CLITHEROE TOWN COUNCIL

12 February, 2013

Planning Application – 3/2013/0094- Advertisements – 7-9 Parson Lane, Clitheroe .

PROPOSED FRONT 1:50

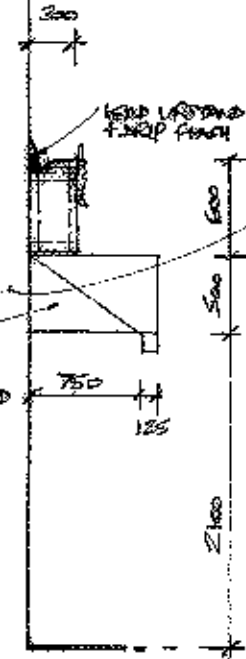
The Town Council have no objection to the application. They do however request that the illuminated sign meets the Borough Council's guidelines.
